CITY OF PORTLAND, MAINE
HISTORIC PRESERVATION BOARD

February 9, 2015

Re: New Construction – Energy Building; Porch Expansion – Doctor’s Residence

PROJECT: House Island - Bldg #2 Former Doctor's Residence JOB NUMBER: 9269-14
 DRAWING TITLE: Sections & Details DRAWN BY: MER
 OWNER APPROVAL: SCALE: As noted

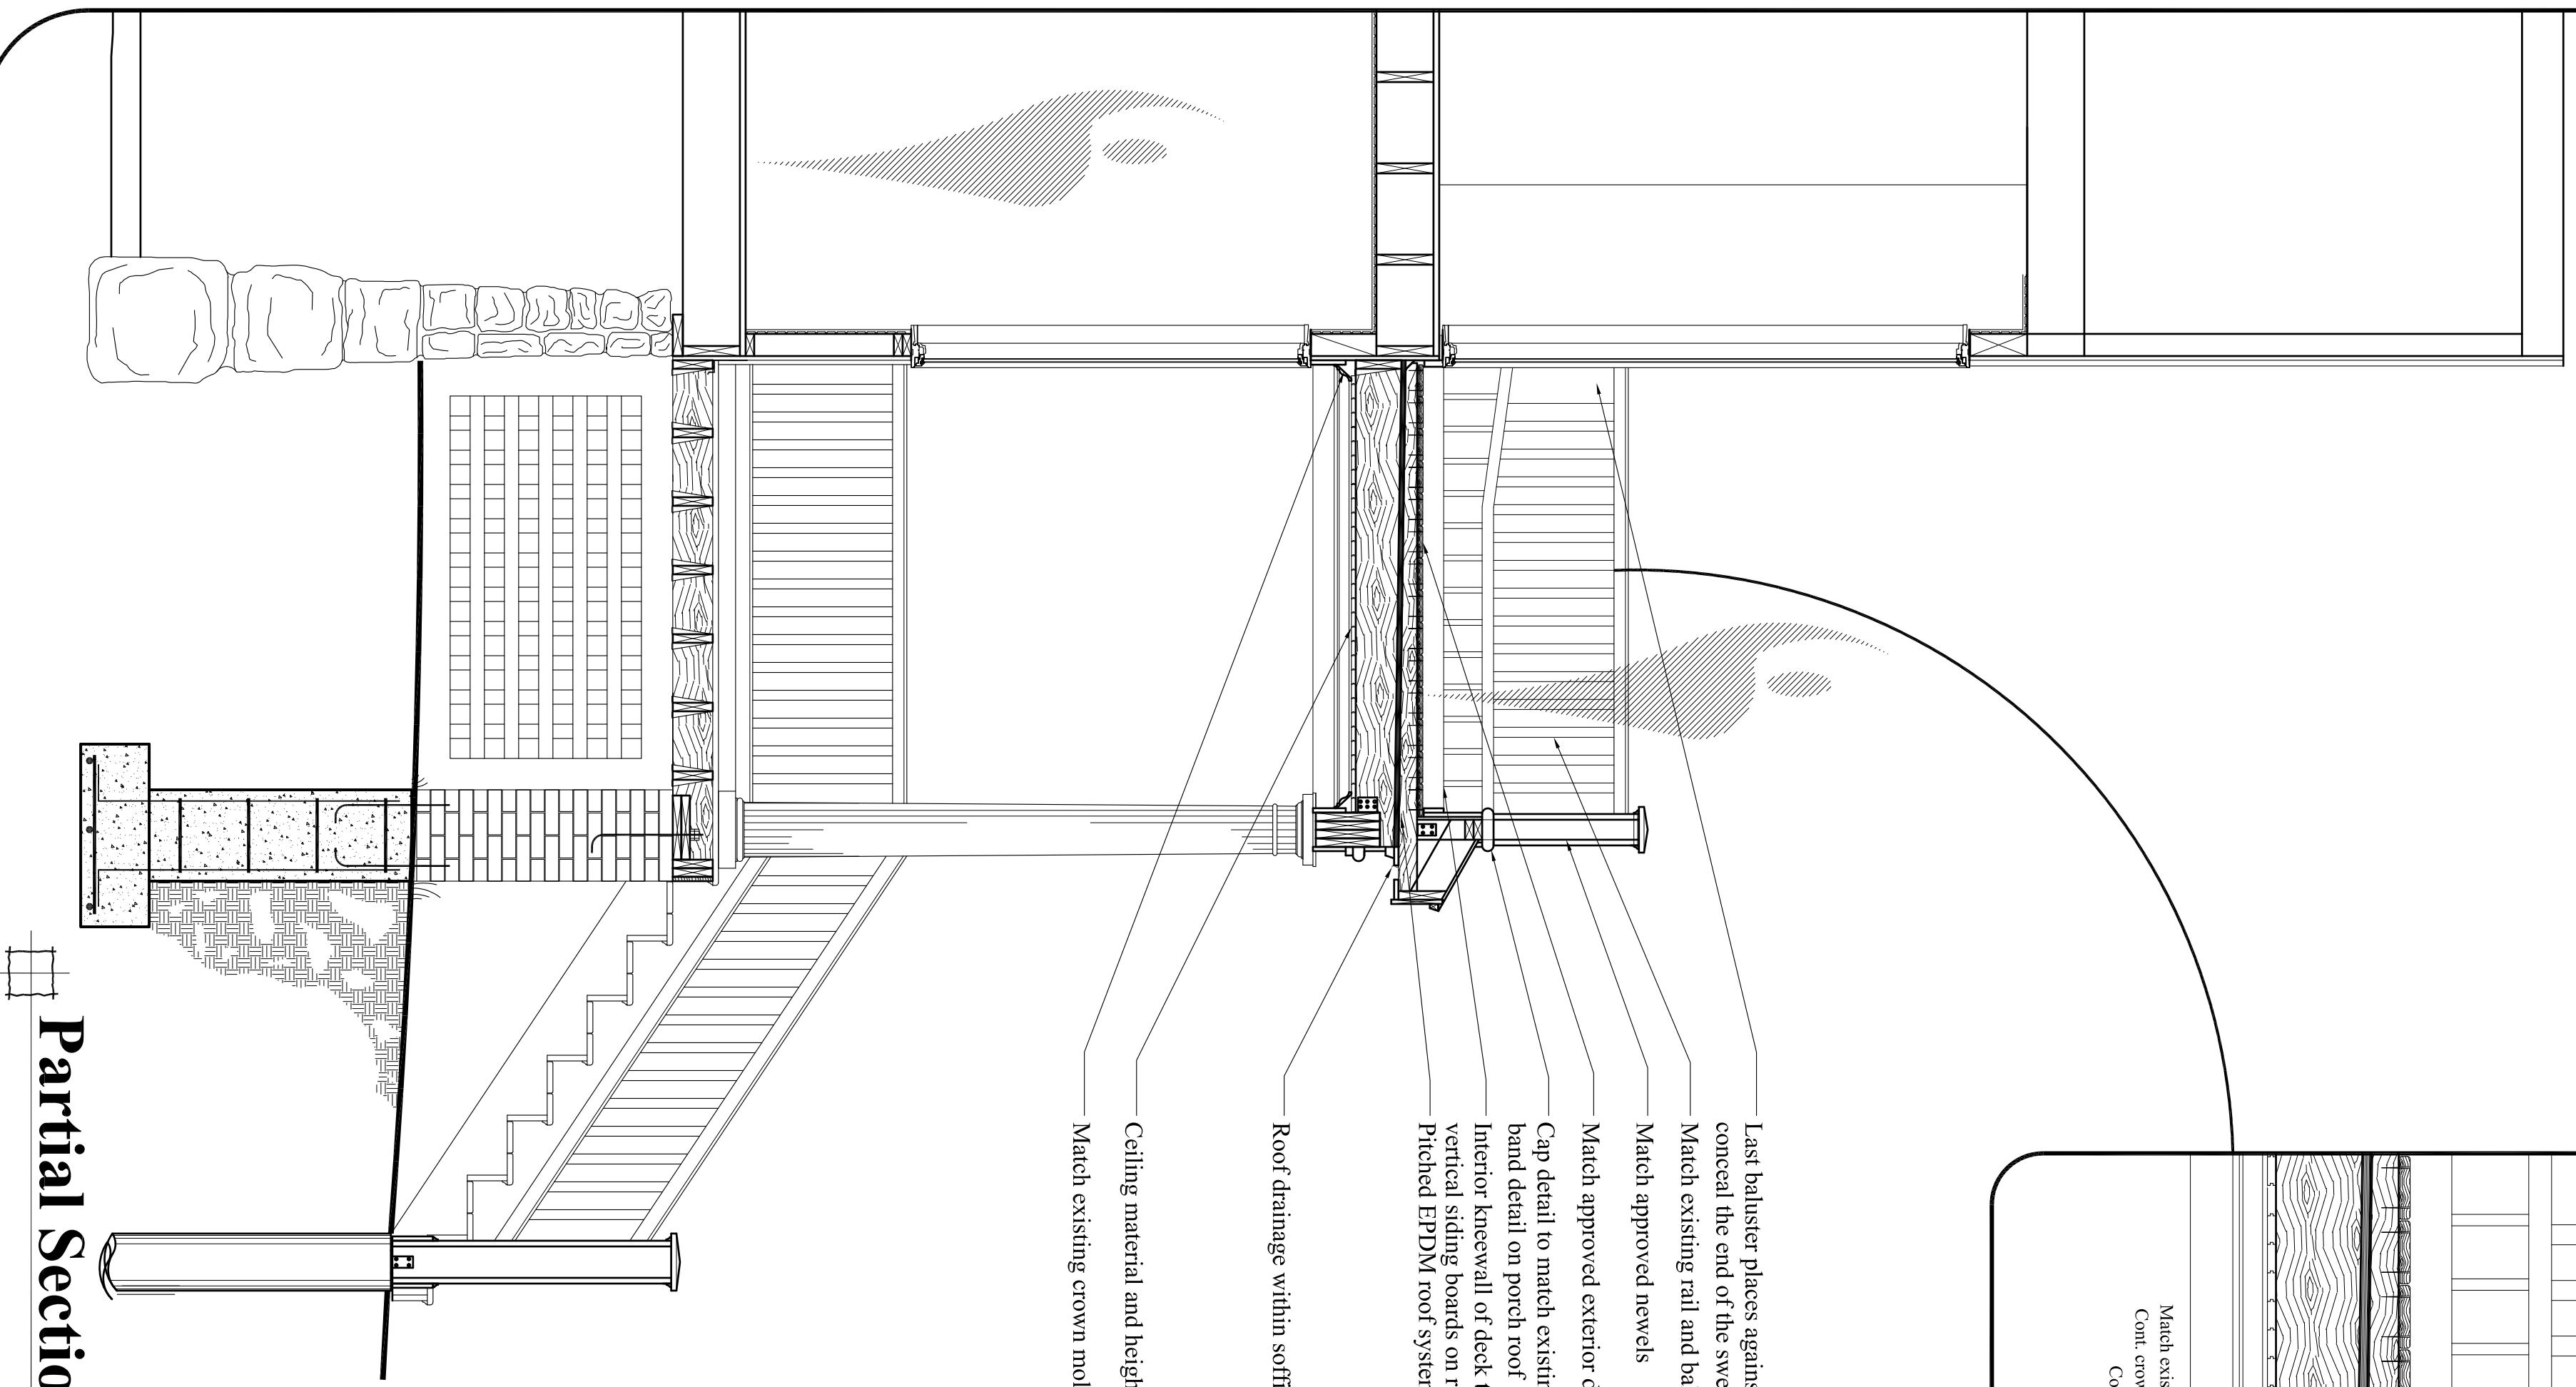
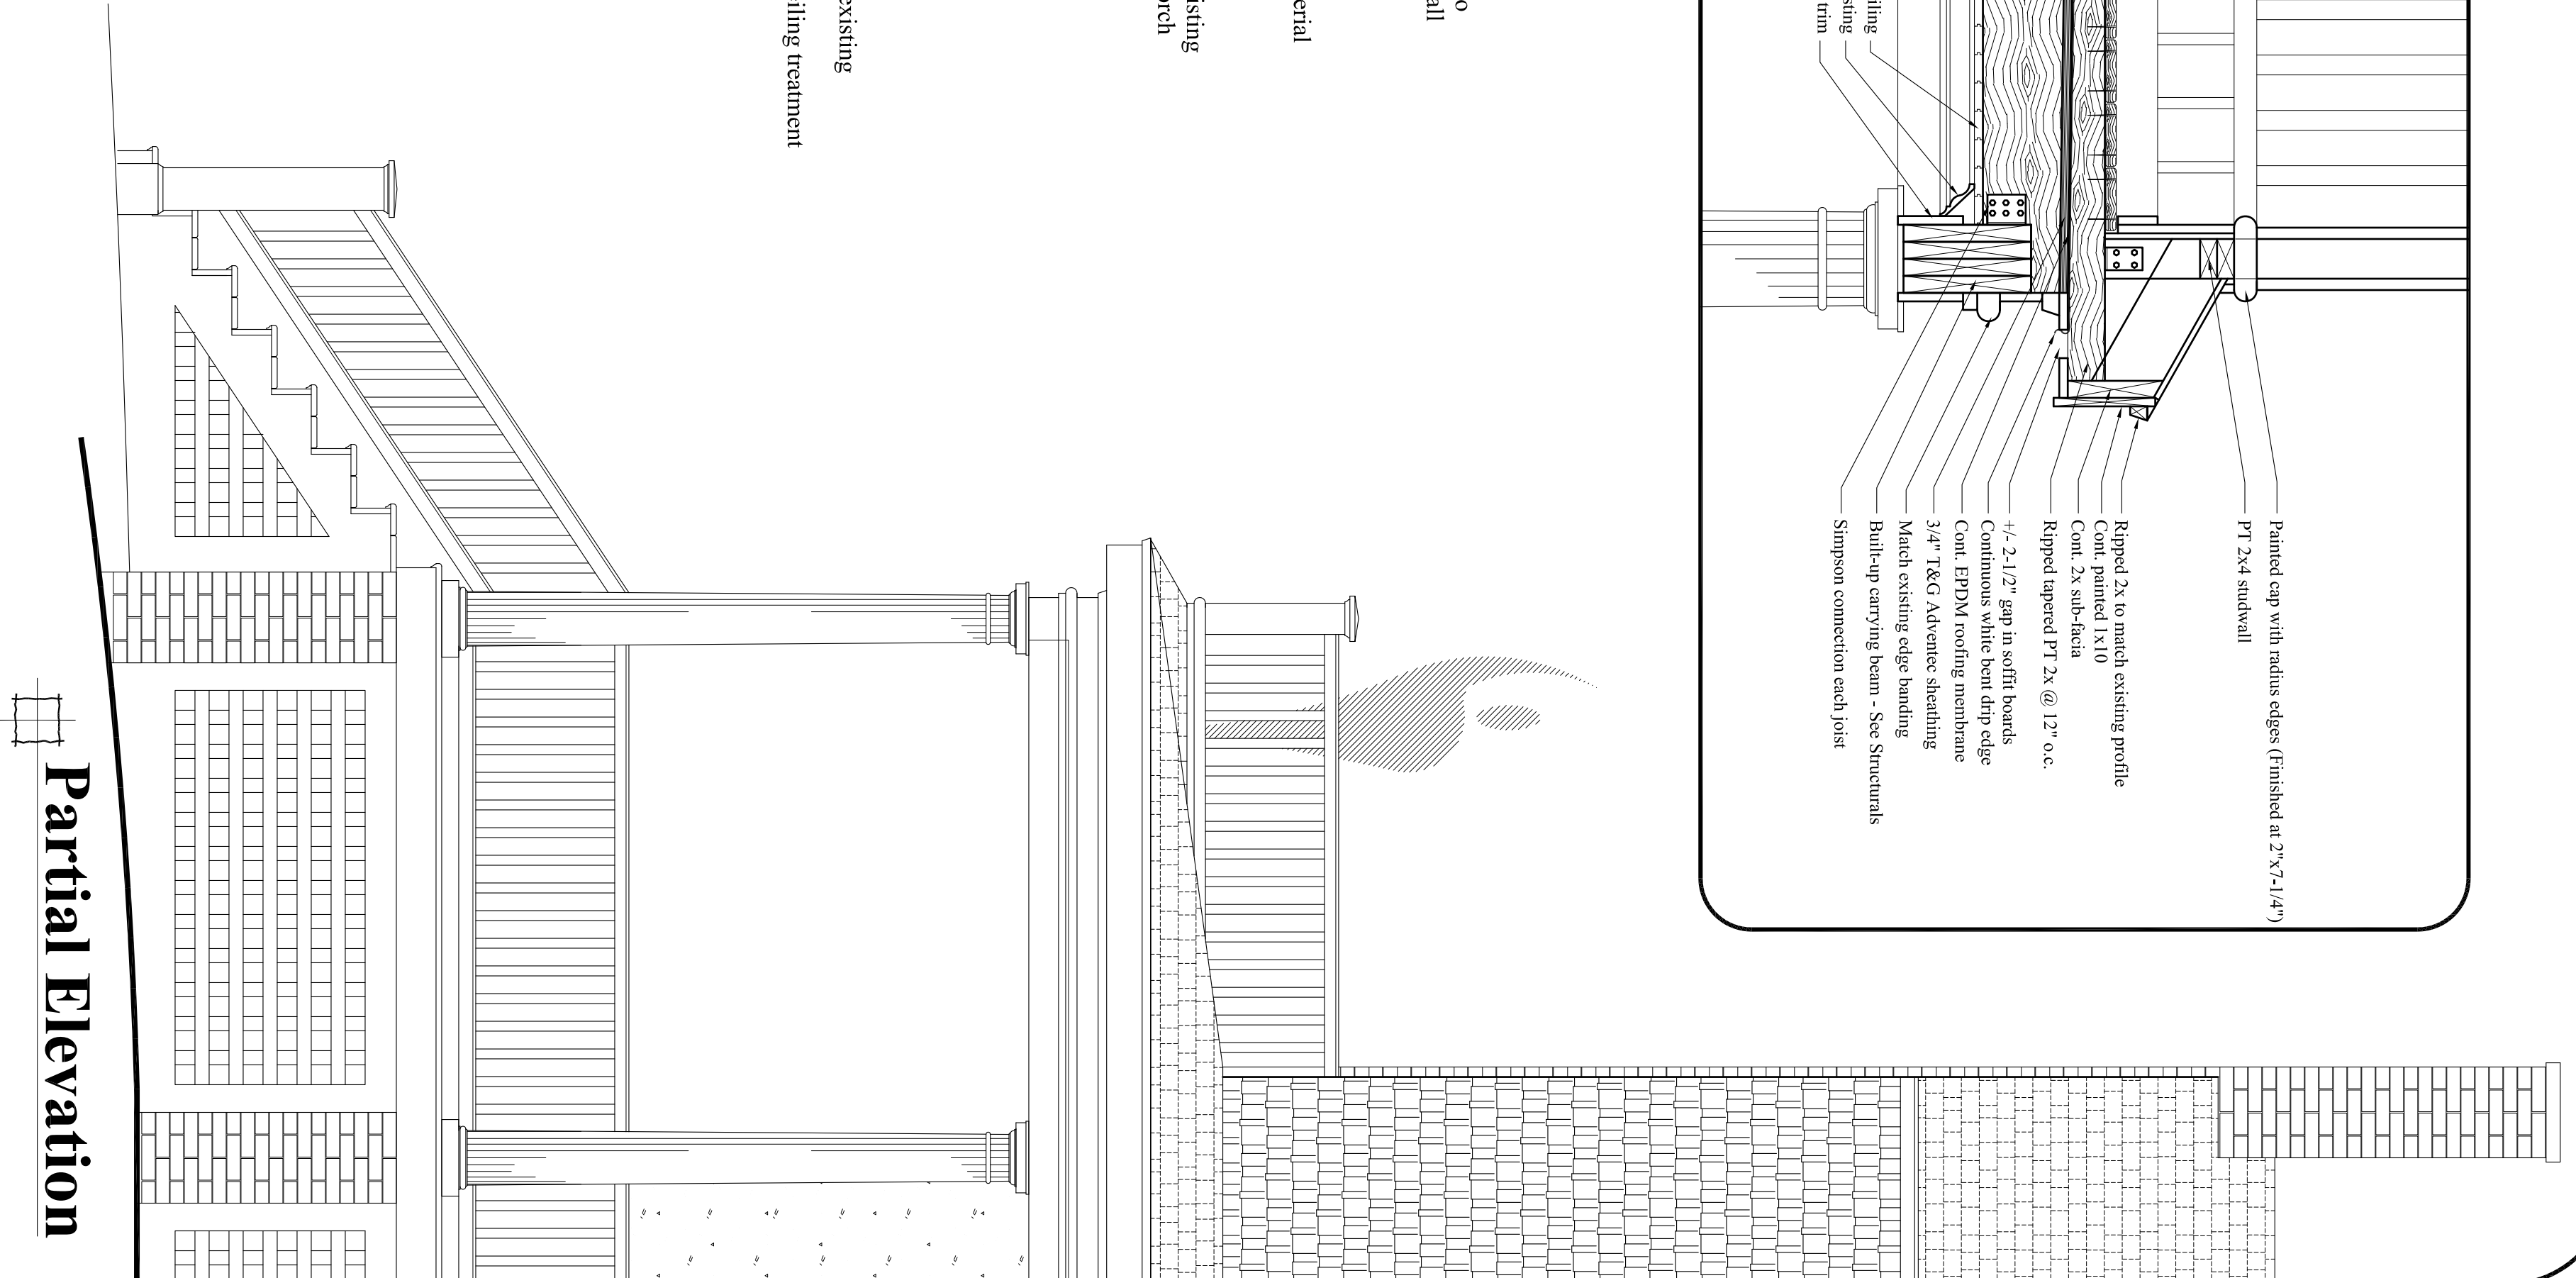
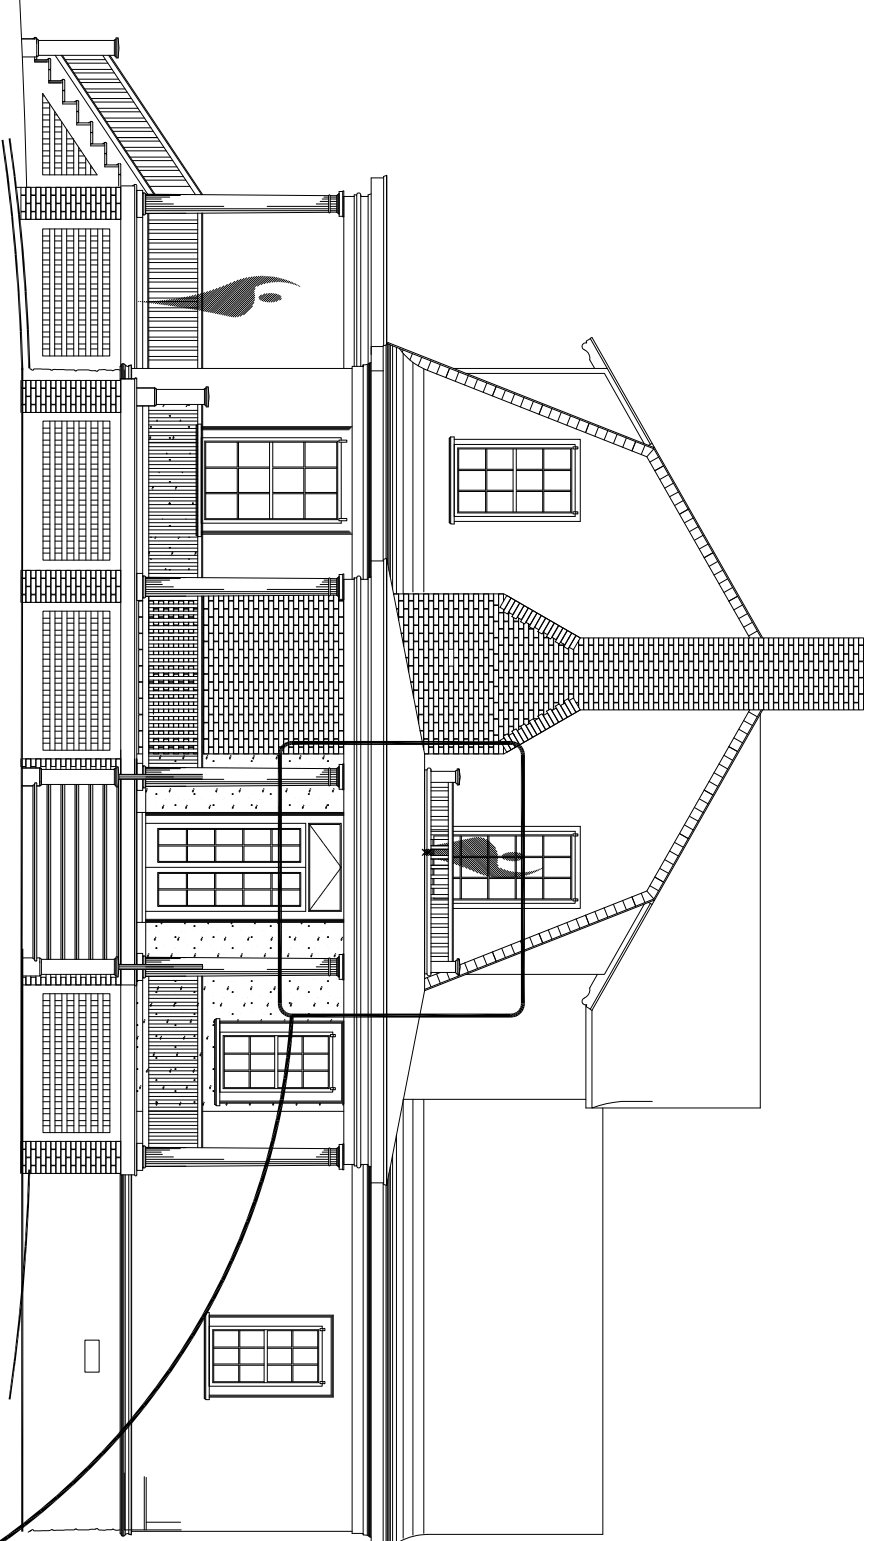
1. Approved Energy Building option includes a glazed cupola that is to be flared at the base, with the same siding treatment as the rest of the building.
2. Location and treatment of the proposed generator and its fuel storage are to be reviewed and approved prior to construction – by staff unless the generator and / or tanks are outside and above ground – in which case the generator plan is to be reviewed by the Board.
3. Balustrades on porches at the Doctor’s Residence are to retain / replicate the original spacing and appearance of the existing balustrades.
